MEMORANDUM

DATE: 06/29/2021

SUBJECT: **On-Call Contract #17-067H-1; PO # 8113073**
Bridge Reviews
Task Order #6: Mesa Top Bridge Submittal - Third Review

**CHANNEL SECTIONS
PROPOSED CONDITIONS**

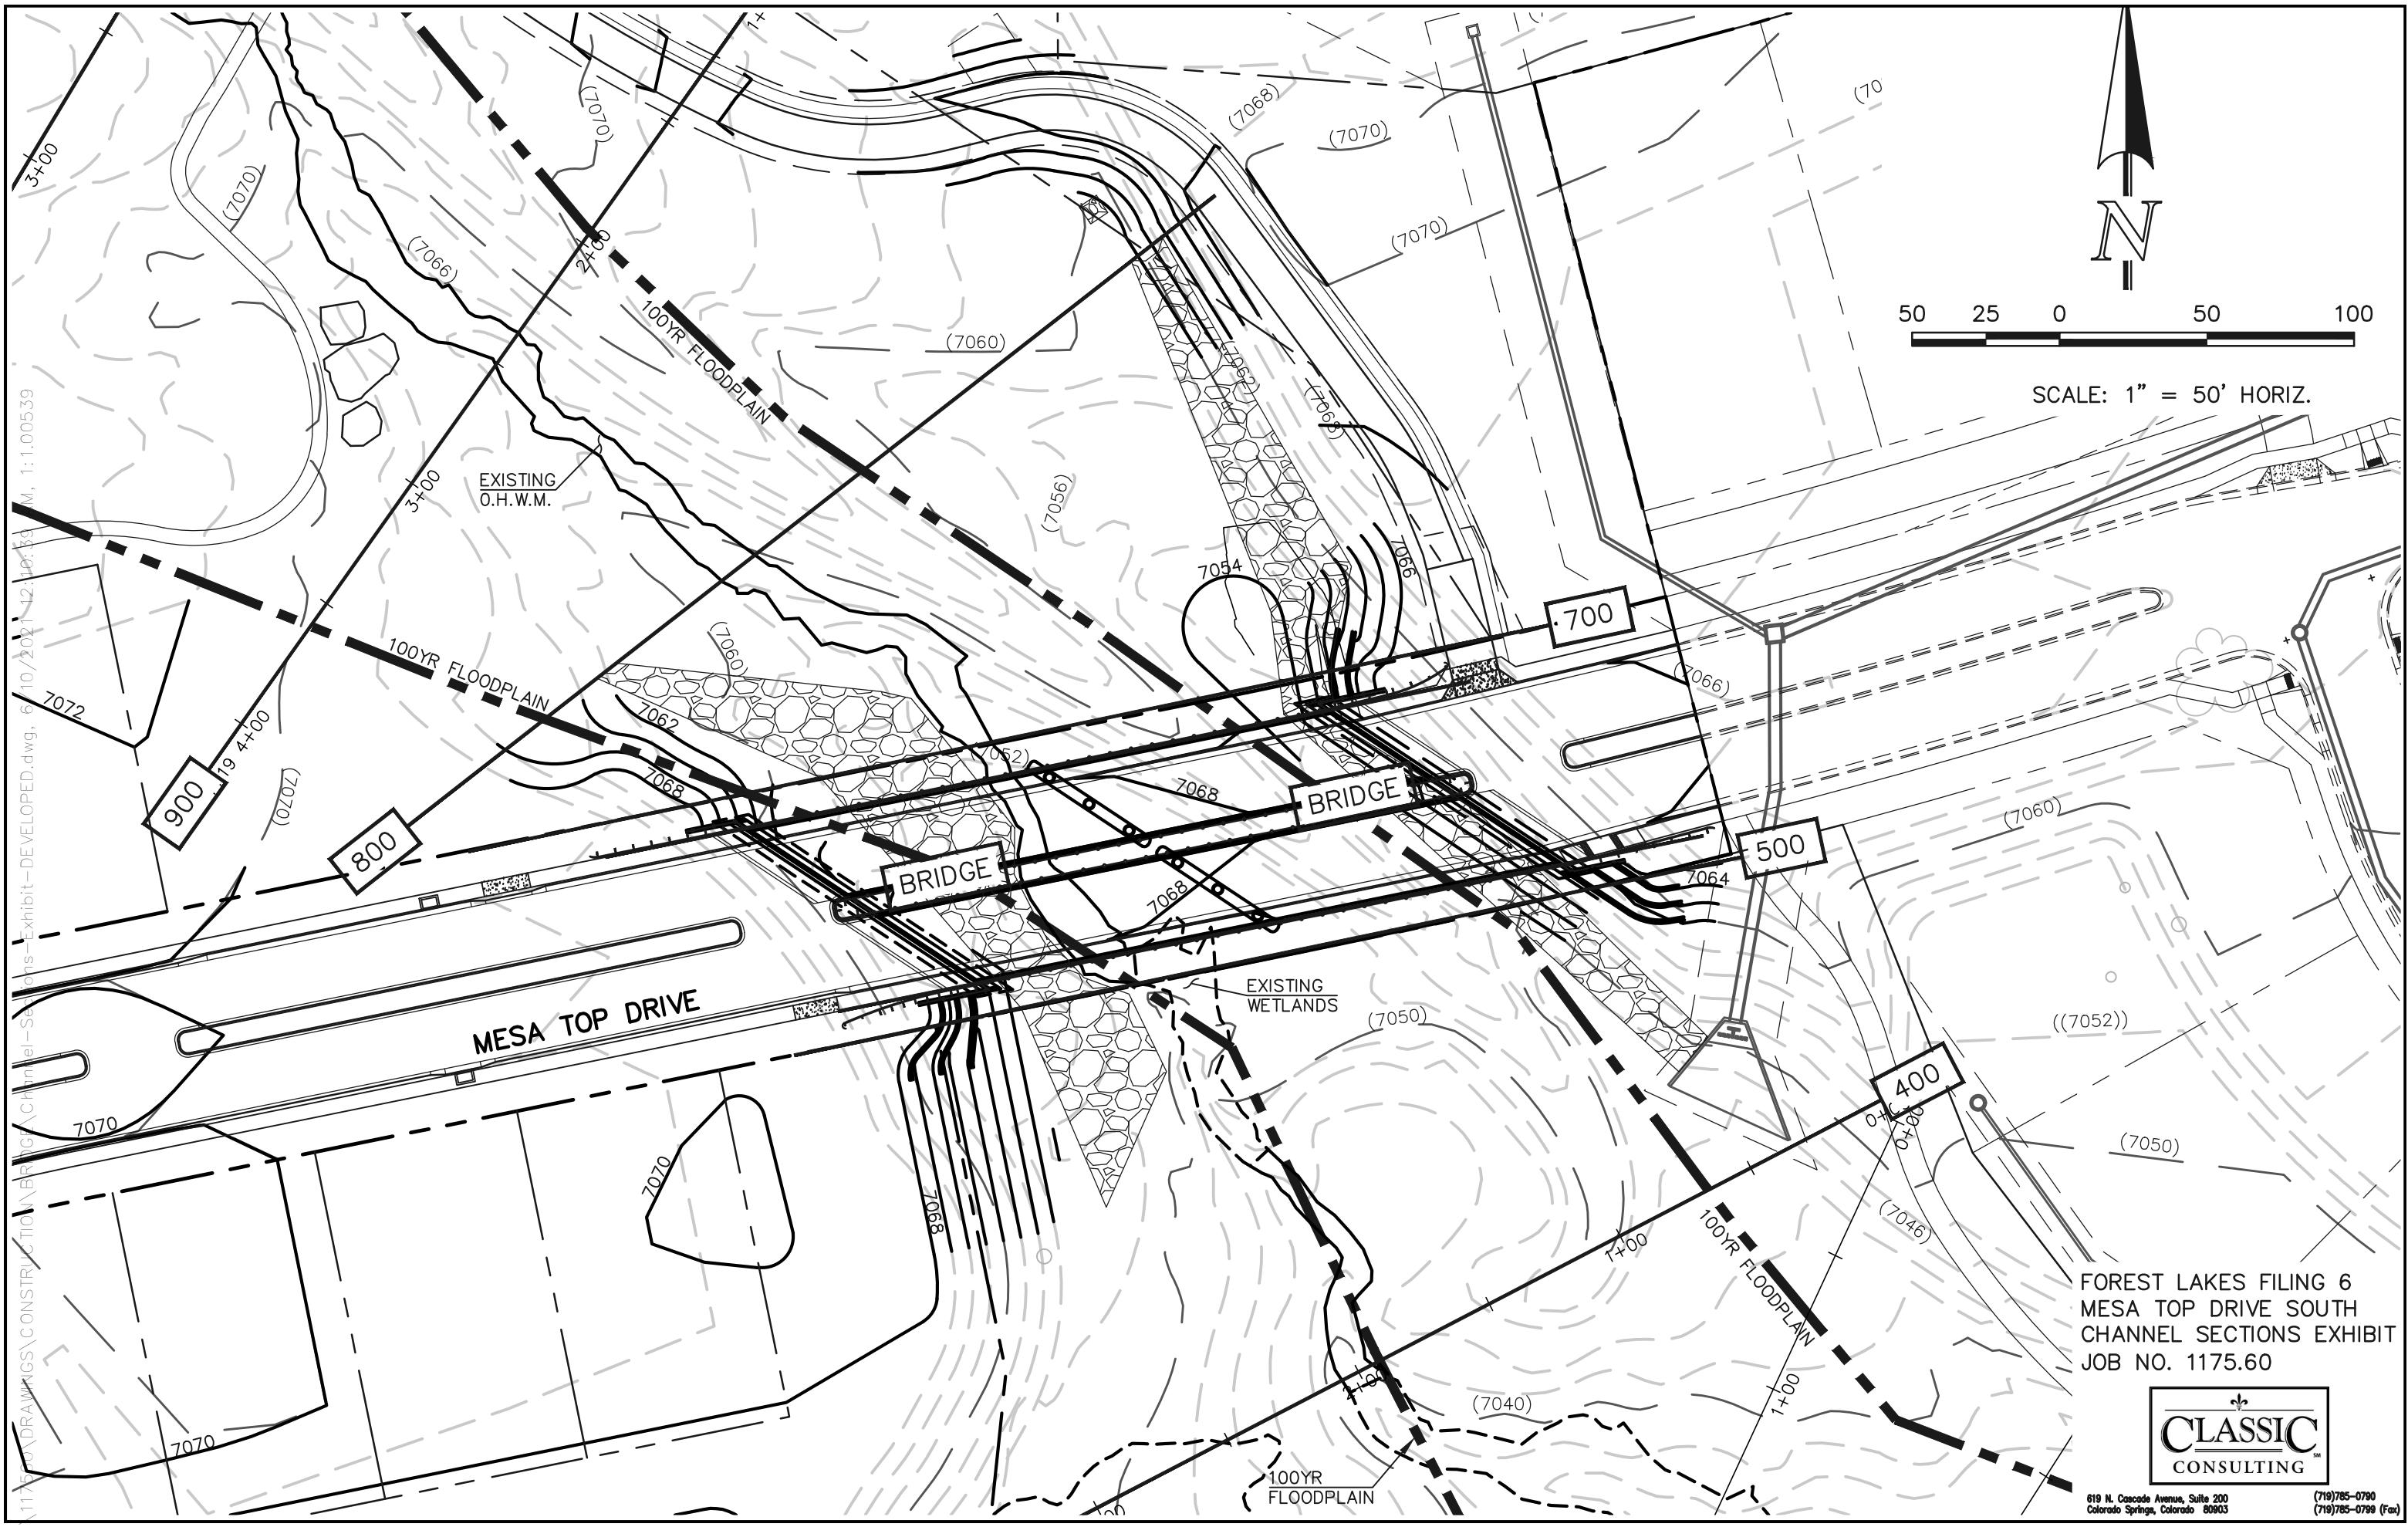
- ✓ Proposed conditions section 700 shows encroachment for both Qs (3123 and 1932) on the left overbank. The contraction coefficient for that section should be increased. A typical value of 0.3 is often used. [Indicated in report text that a value of 0.3 was used. The HEC-RAS file was not included so was not verified.](#)

2. Add discussion about increase in water surface elevation at section 700 from 7056.80 ft (existing conditions) to 7056.89 (developed conditions). Is this increase within the criteria to not require a CLOMR for this project? The HEC-RAS model was not provided and the HEC-RAS printouts in the appendix are for the higher Q100. I can't confirm if there is still a rise in the water surface elevations and the report discussion does not address if there's a rise that would trigger a CLOMR.
